Your Ref: OWPC21006
Our Ref: A/158/18/PL 23-11-2018
Please ask for:
Mrs A Gardner

Variation of condition 1 imposed under A/8/18/PL relating to the substitution of approved plan drawings NO ADC 962 04 rev A & 13 rev B for drawings No ADC 962 20 & 21 (ground & first floor plans & roof plan). This application affects the character & appearance of the Angmering Conservation Area.

Land Rear Of 1 To 6 The Cottrells Angmering

Rev	Description	Date
Job Reference		
New House The Cottrells Angmering, BN16 4AF		Client AM Homes Ltd
Drawing Title Ground Floor Plan		Drawing No ADC962/20
Date 23.11.18	Scale 1:100	Dwg Size A3
Plot Style ADC-red	Drawn TOS	Checked AD

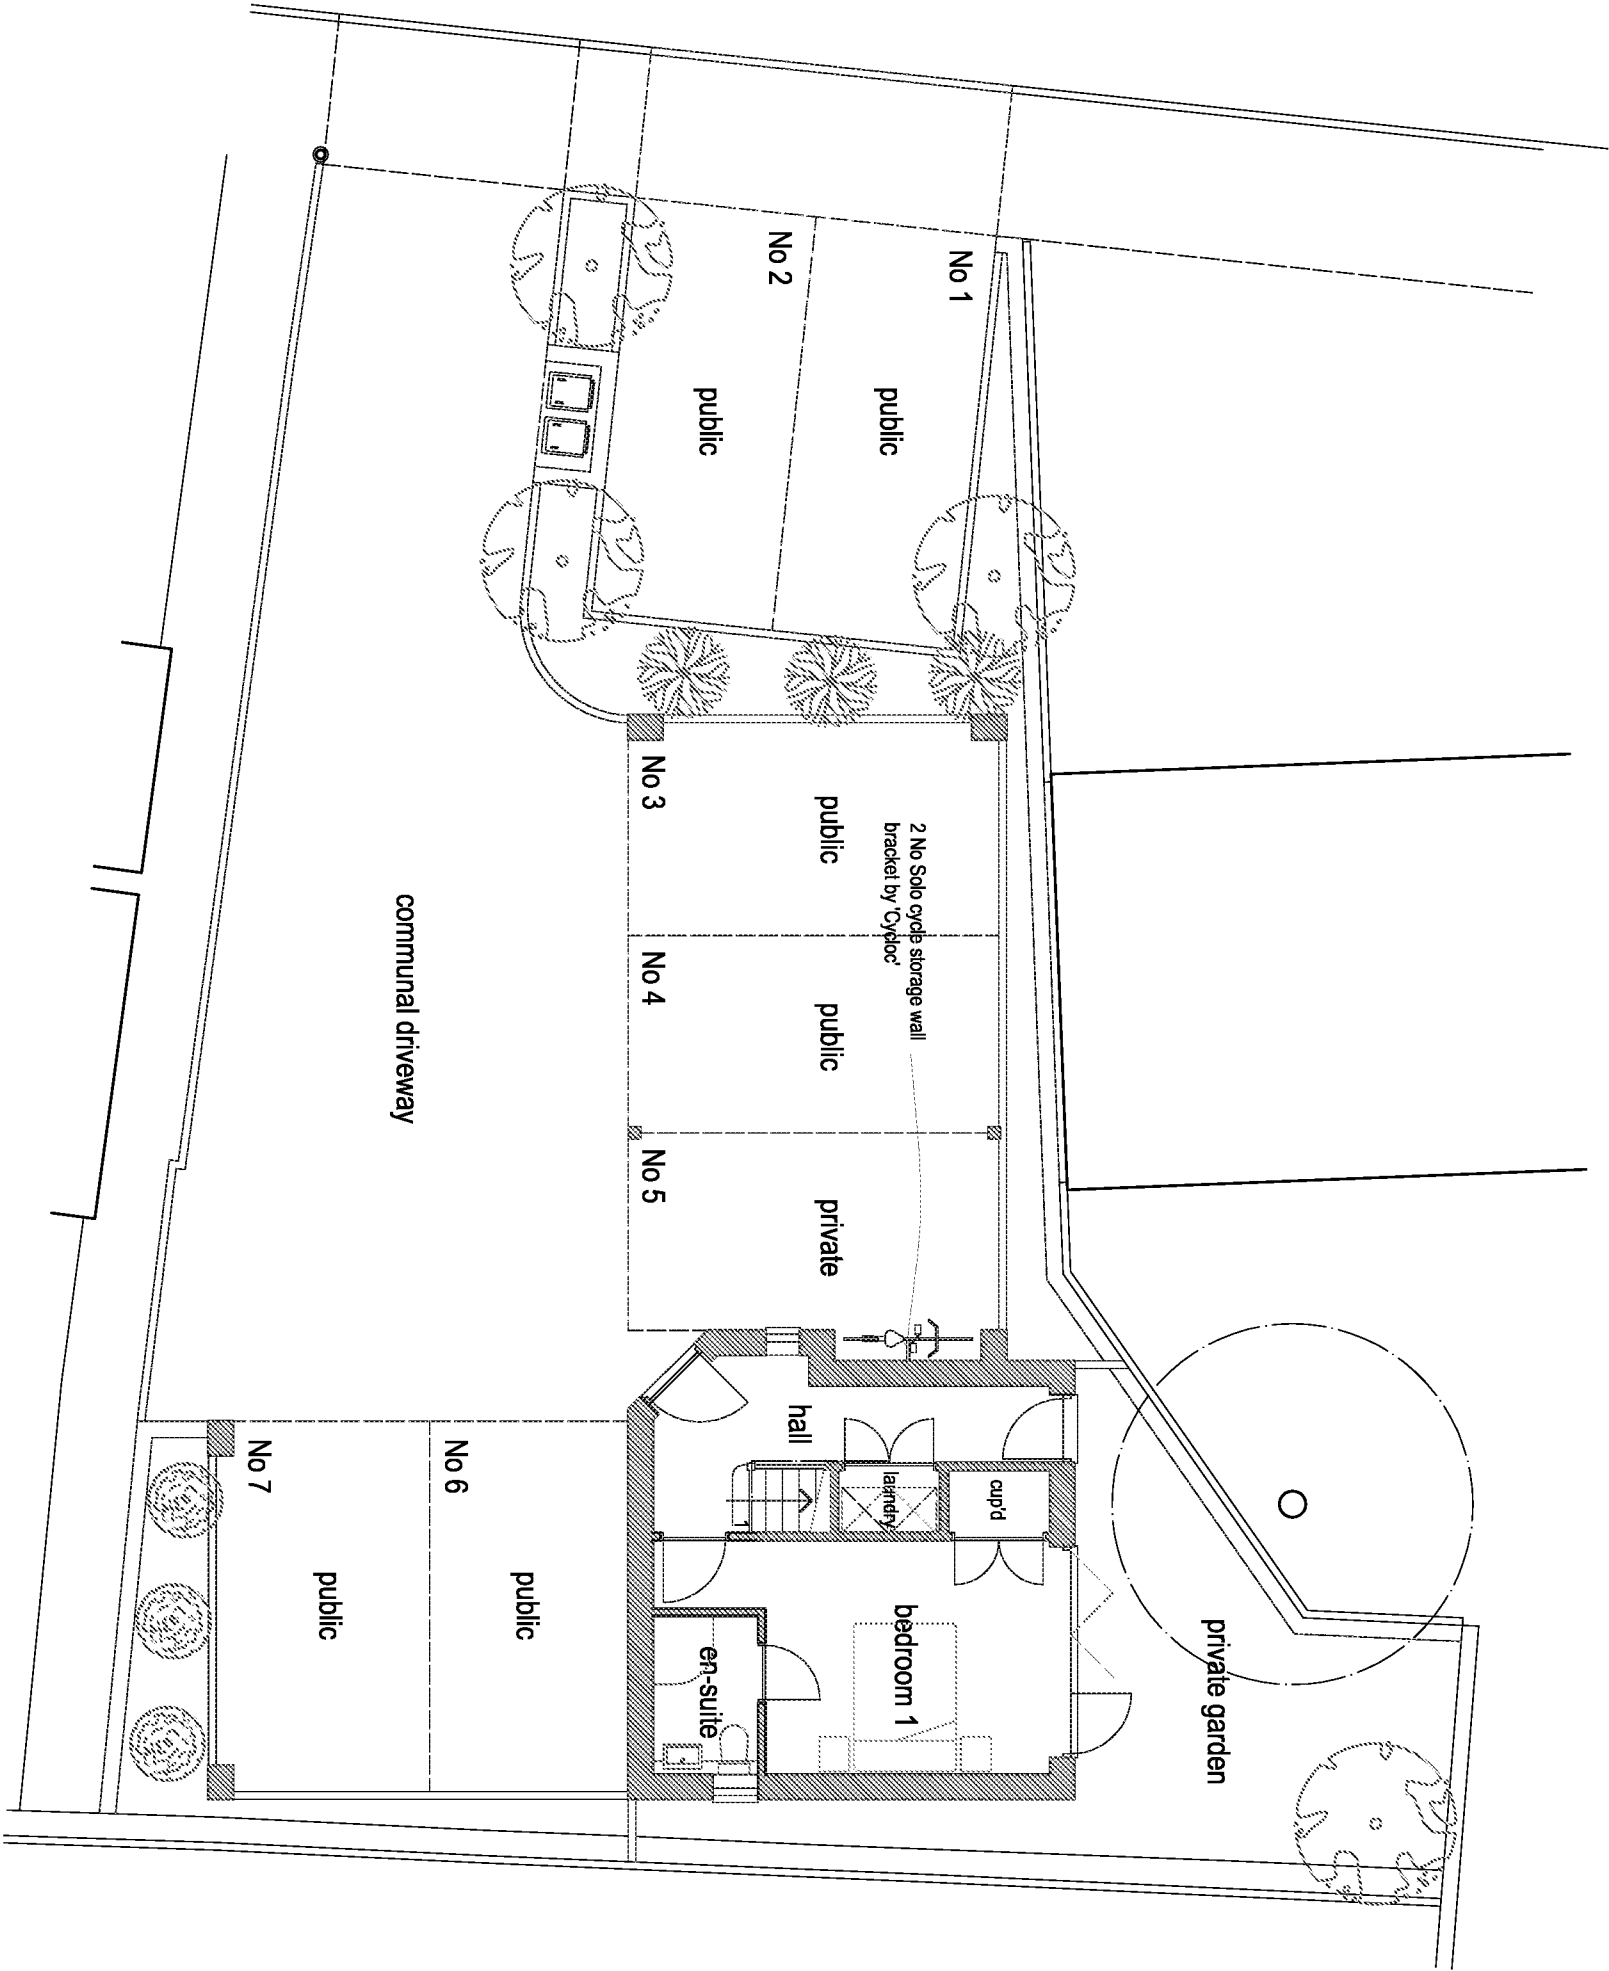
I strongly object to this application. The building as constructed is not as the approved plans, in fact it is extremely similar to those plans that have already been rejected. A third bedroom has now been included contrary to ADC clearly making the statement that the building is not to exceed two bedrooms. A third bedroom will obviously result in yet another vehicle for which there is not the parking space. Residents vehicles already spill out into the High Street.

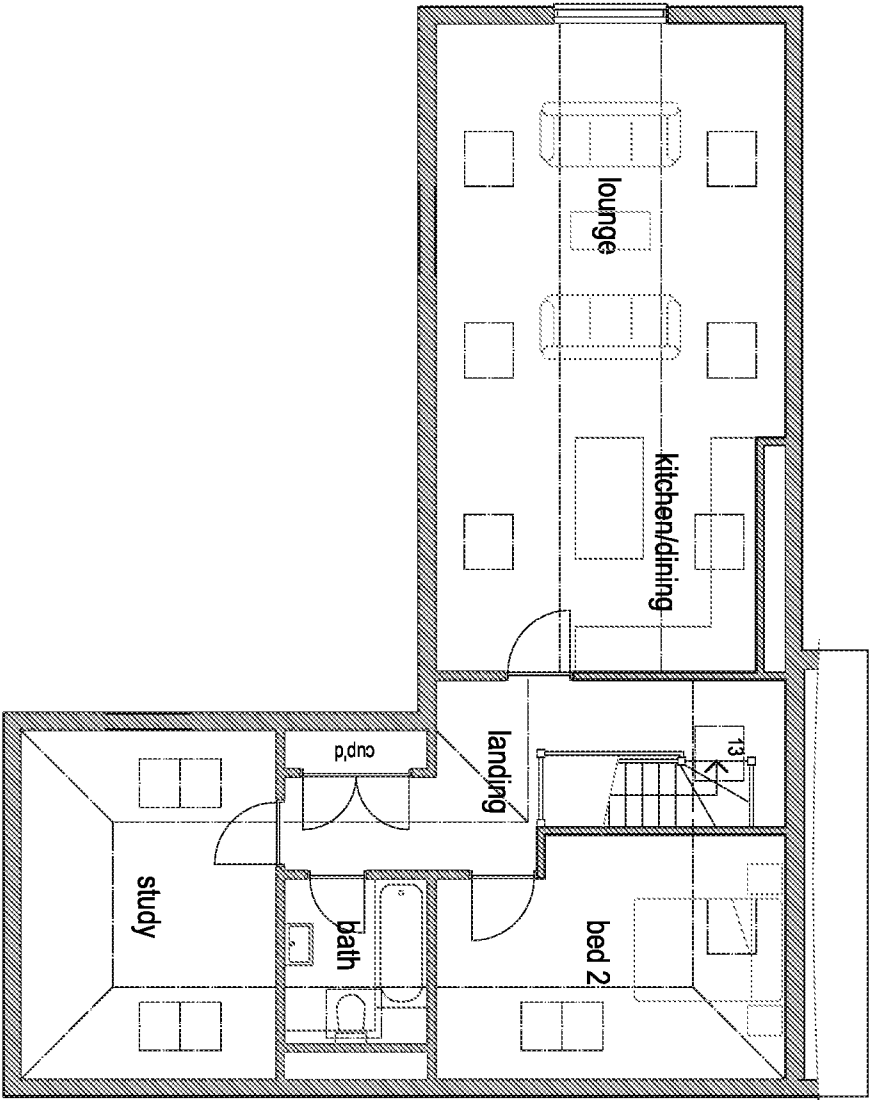
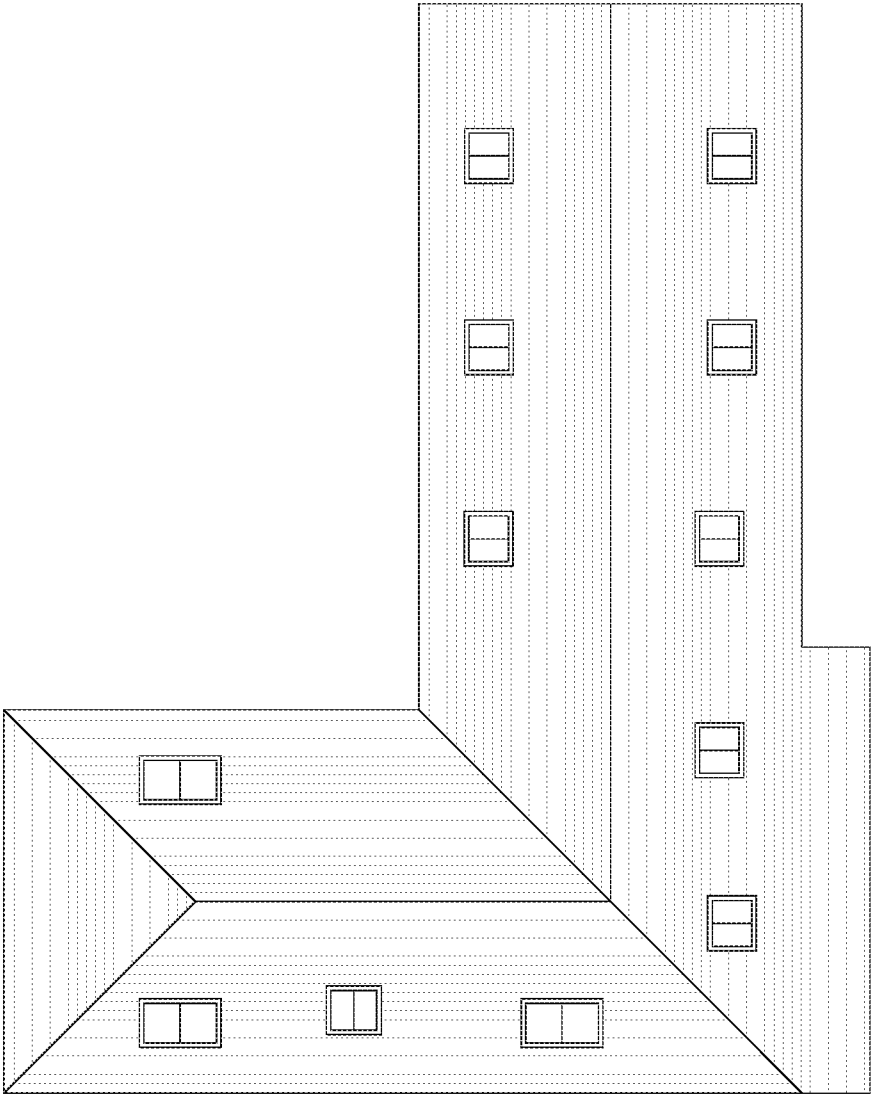
There is also the matter of the roof lights which are both not as the approved design and are now lower invading the privacy of the residents of 1 to 6.
